CITY OF ALBUQUERQUE

February 20, 2018

**Re: File-Gul Development
Erosion and Sediment Control Plan
Engineer's Stamp Date 2-13-18 (G13E033)**

EROSION AND SEDIMENT CONTROL PLAN

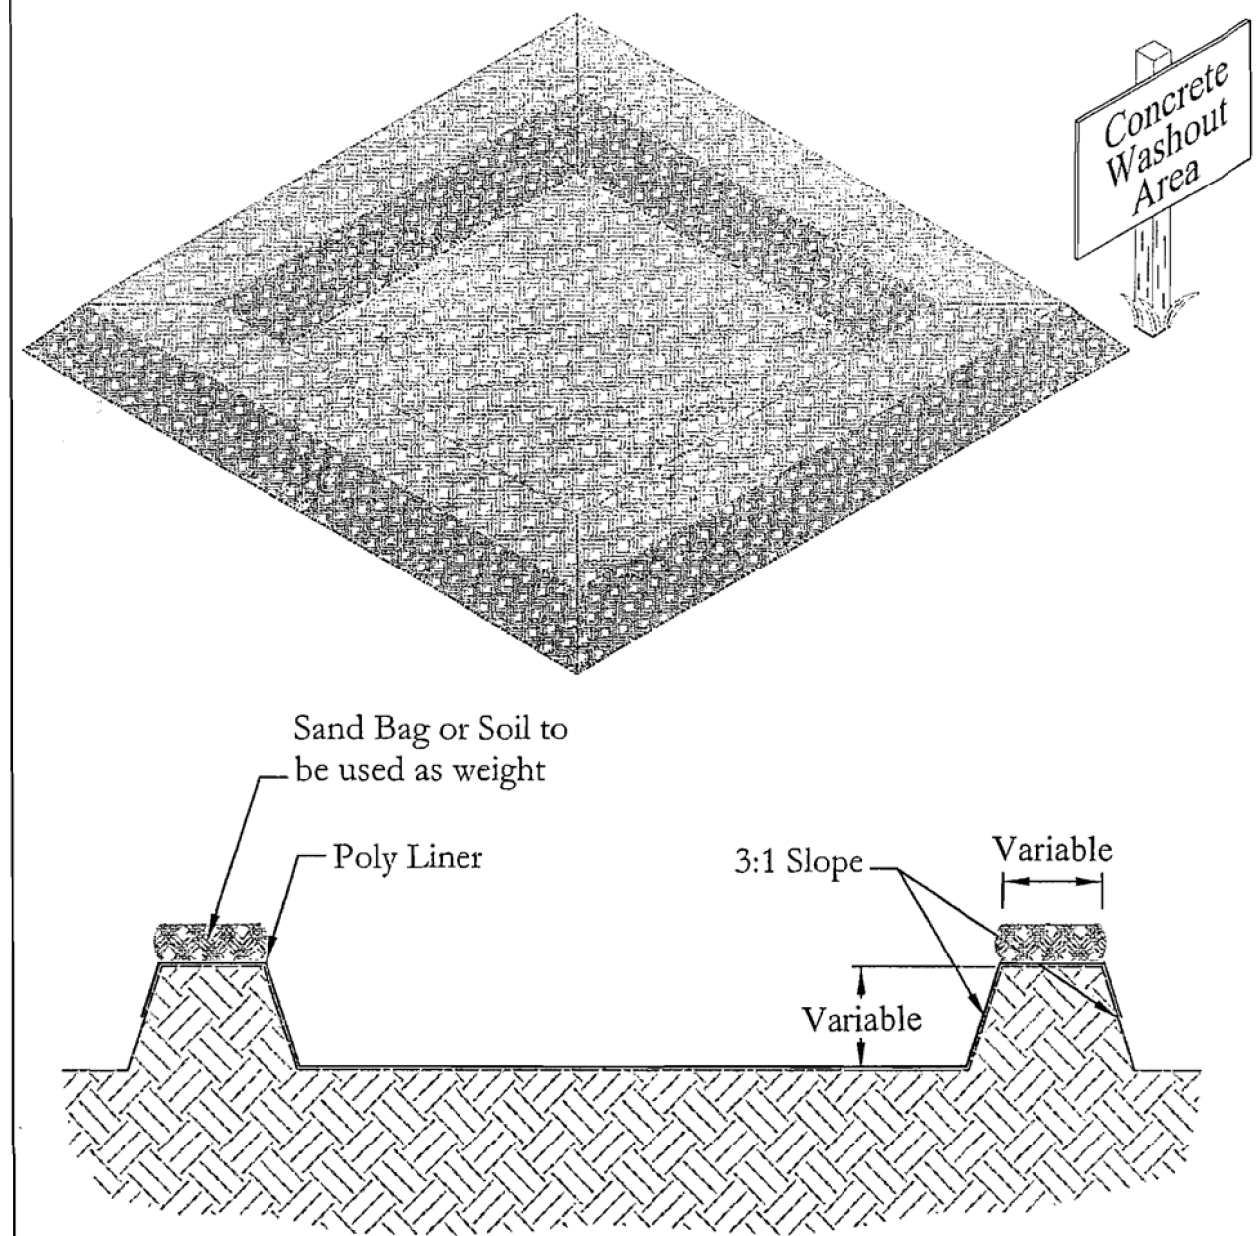
After the internal street is constructed, sediment BMPs may be required on the lots as the driveways are graded to drain to the internal street and the inlet protection in Matthew Ave may be able to be removed.
